KITTITAS COUNTY

MEMORANDUM

TO: All Staff
FROM: Public Works Plan Review Team
DATE: August 2nd, 2023
SUBJECT: Public Works Comments: SP-23-00005 Craig

SWEETWATER SHORT PLAT
PART OF SECTION 29, T. 19 N., R. 19 E., W.M.
KITTITAS COUNTY, WASHINGTON

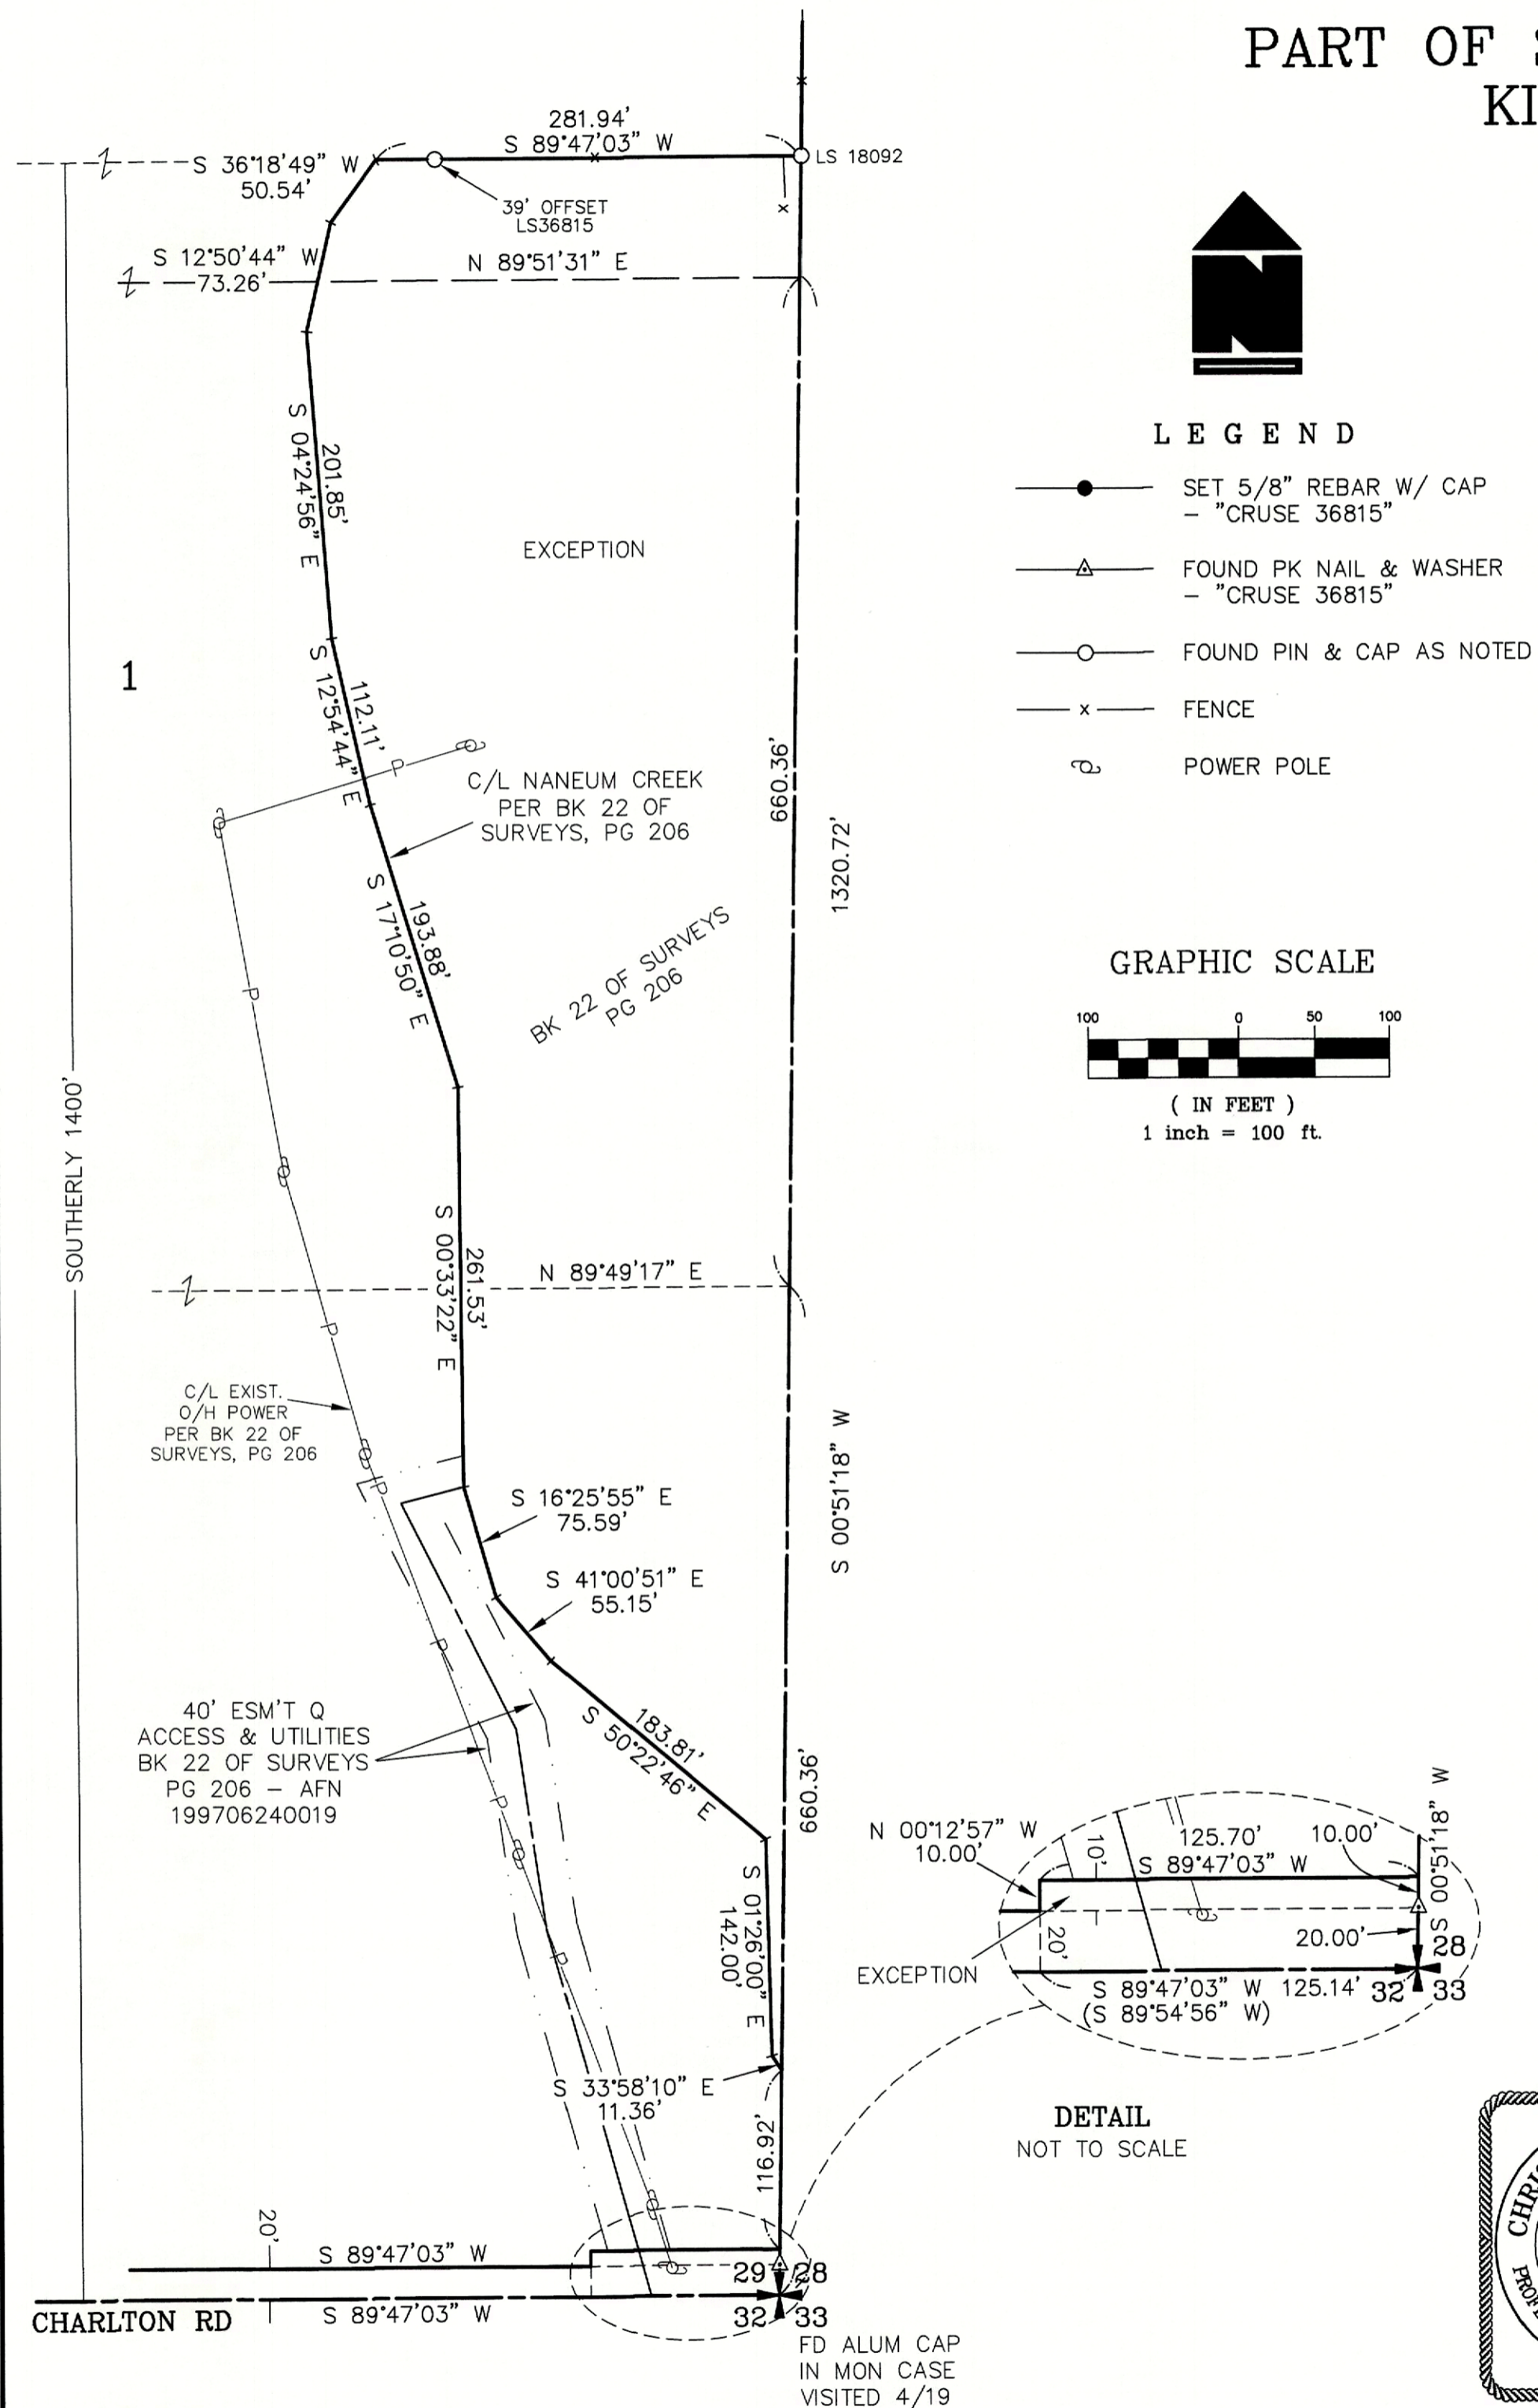
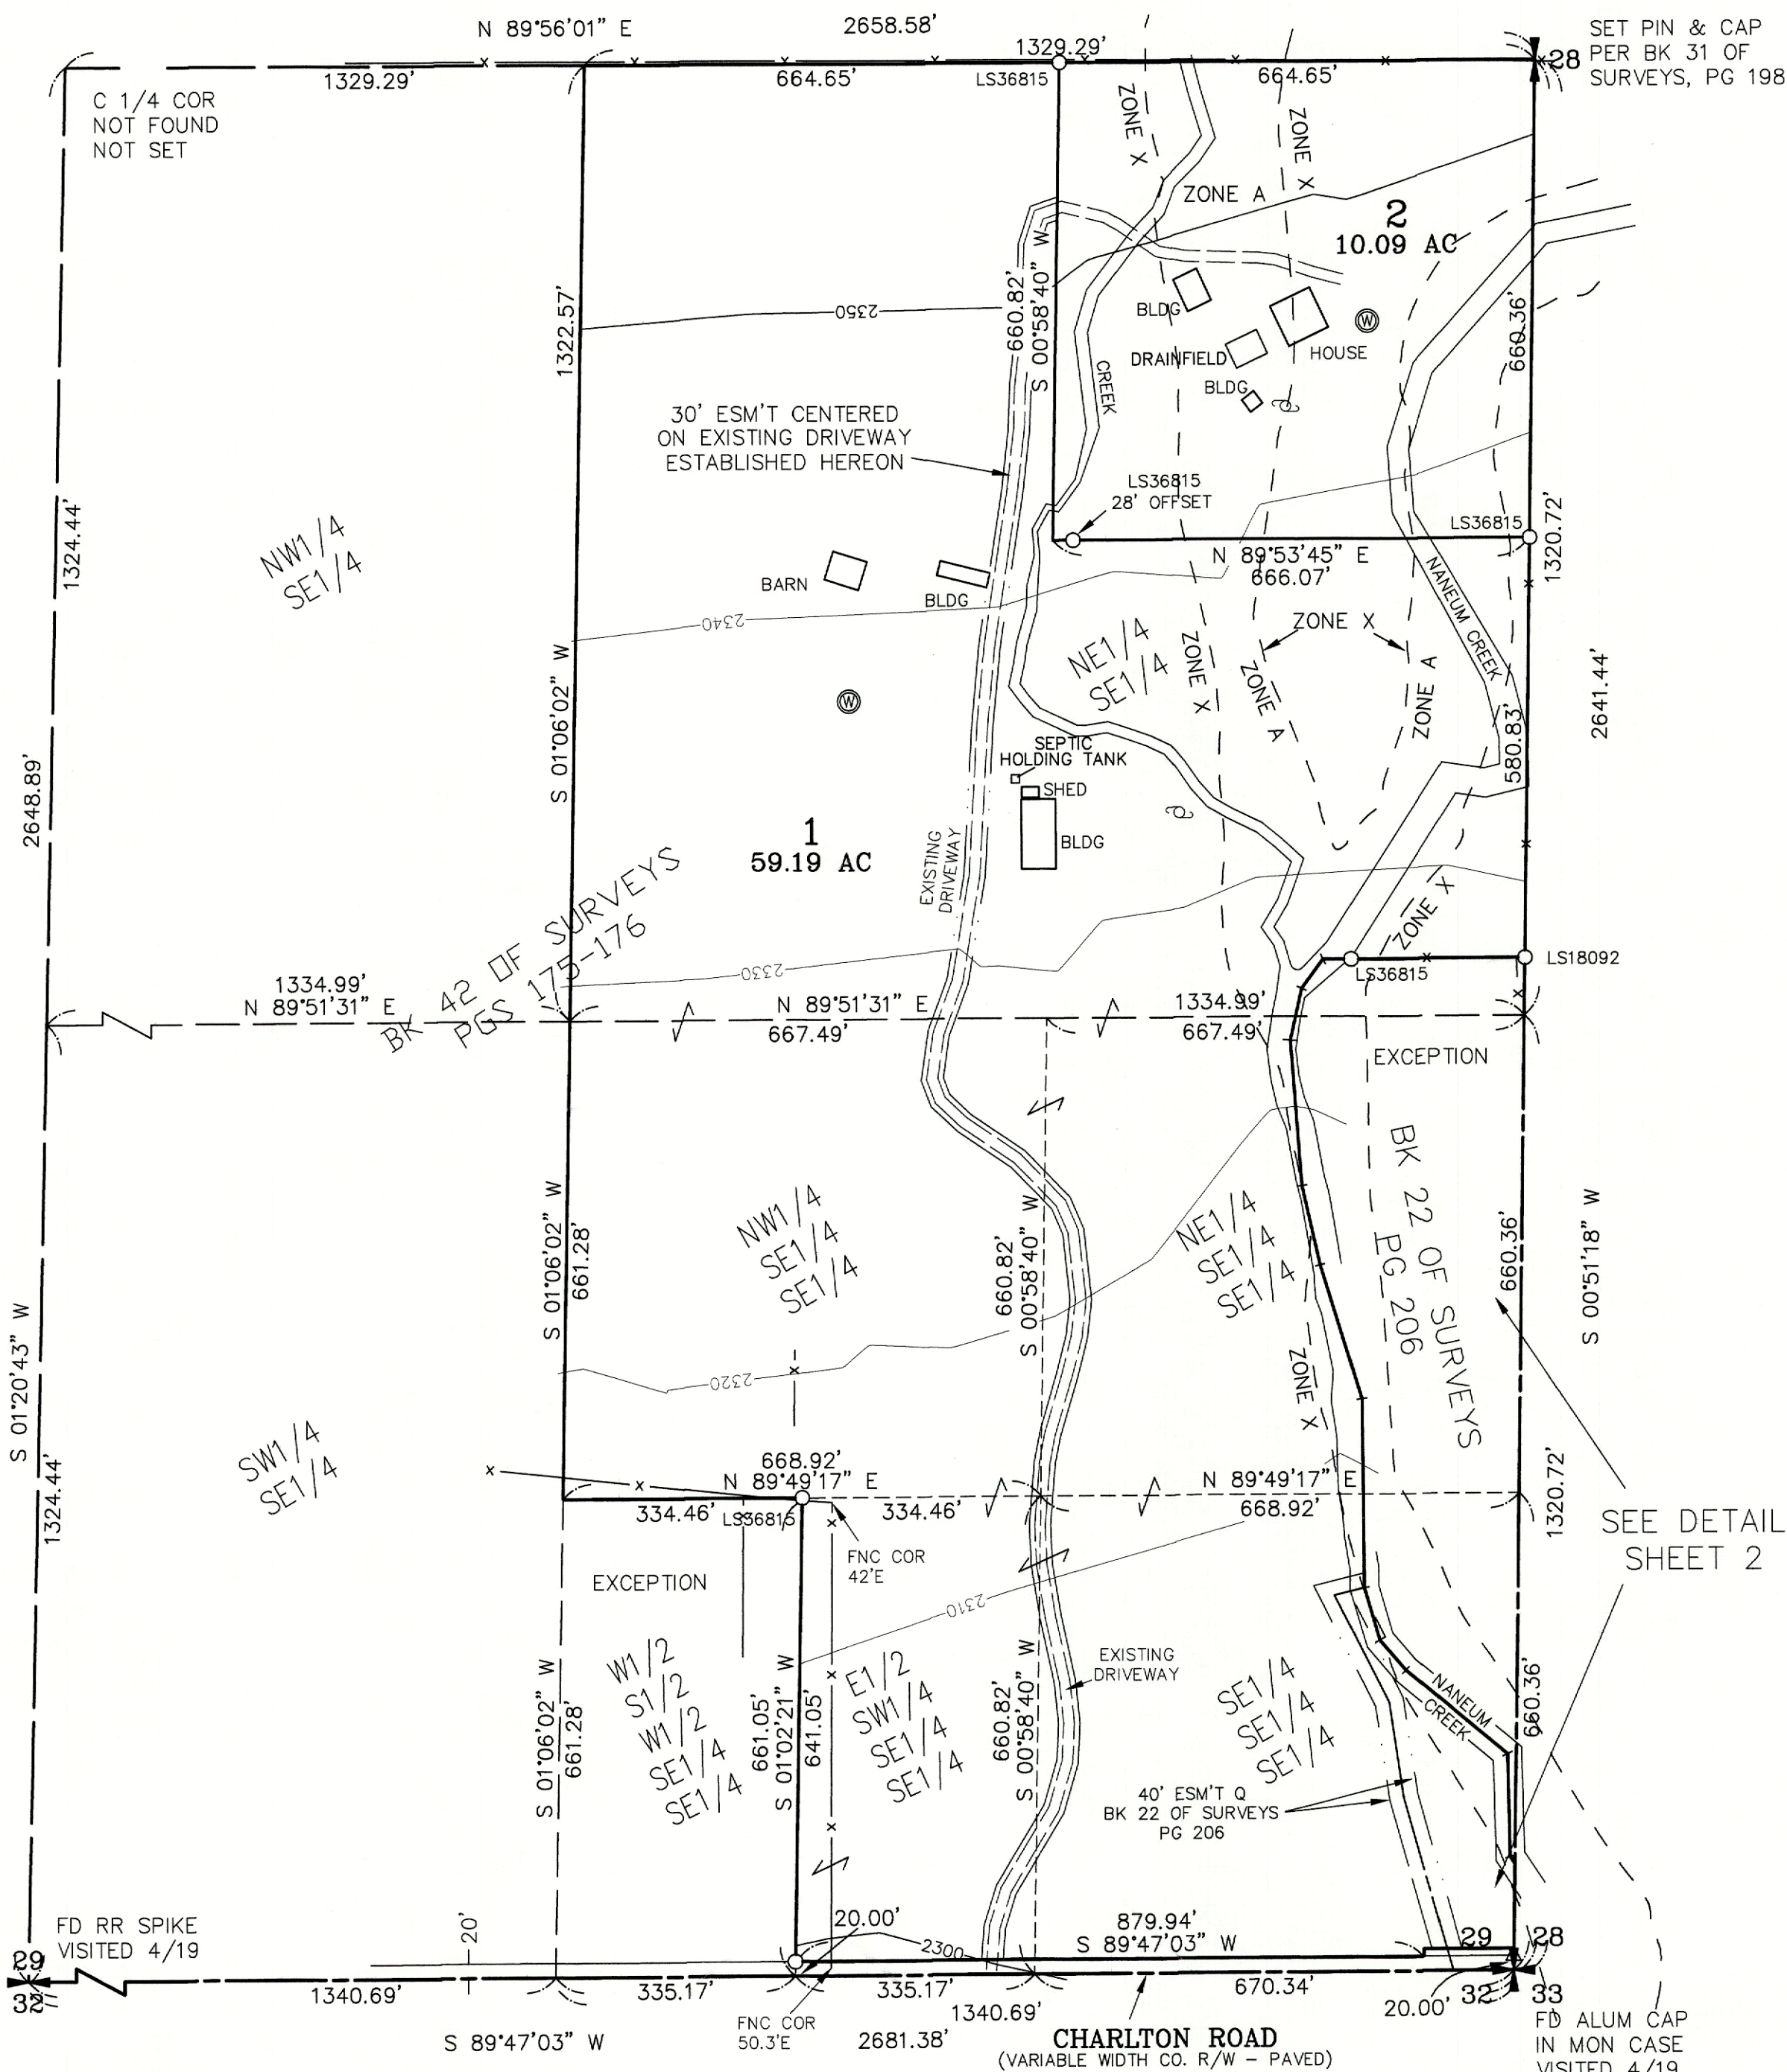
SURVEY	<p>Following comments will need to be addressed on Final Short Plat. There are no required changes for the Prelim submittal.</p> <ol style="list-style-type: none"> 1. Set property corners where required. There is no need to set corners in the area that generally follows the course of Naneum Creek. 2. Correct typo on first exception of parcel description "oad" to "road".
TRANSPORTATION CONCURRENCY	<p>No transportation concurrency comments. The two-parcel short plat will not create more than nine (9) peak hour vehicle trips. KCC 12.10.040(C)</p>

<p>FLOOD</p>	<p>Portions of parcels 558434 and 205736 are within the FEMA identified special flood hazard area (100-year floodplain) zone A. If possible, any future development should occur outside of the floodplain in order to reduce risk and avoid mandatory flood insurance purchase requirements. All activities within the floodplain must be permitted through the floodplain development permit process and follow the regulations within KCC 14.08.</p> <p>In accordance with KCC Chapter 14.08.220, All subdivisions as well as new development shall:</p> <ol style="list-style-type: none"> 1. Be consistent with the need to minimize flood damage. 2. Have public utilities and facilities such as sewer, gas, electrical, and water systems located and constructed to minimize flood damage. 3. Have adequate drainage provided to reduce exposure to flood damage. 4. Where base flood elevation data has not been provided or is not available from another authoritative source, it shall be generated for subdivision proposals and other proposed developments containing greater than 50 lots or 5 acres (whichever is lesser) and shall be included as part of the application and shall be noted on the final mylar. 5. All subdivisions shall show on the face of both the preliminary and final plat, for either short or long plats, the boundary of the 100year floodplain and floodway. <p>Since the parcels are located in zone A, KCC 14.08.220(4) is applicable. Please contact the Floodplain Administrator at 509-962-7523 for assistance.</p>
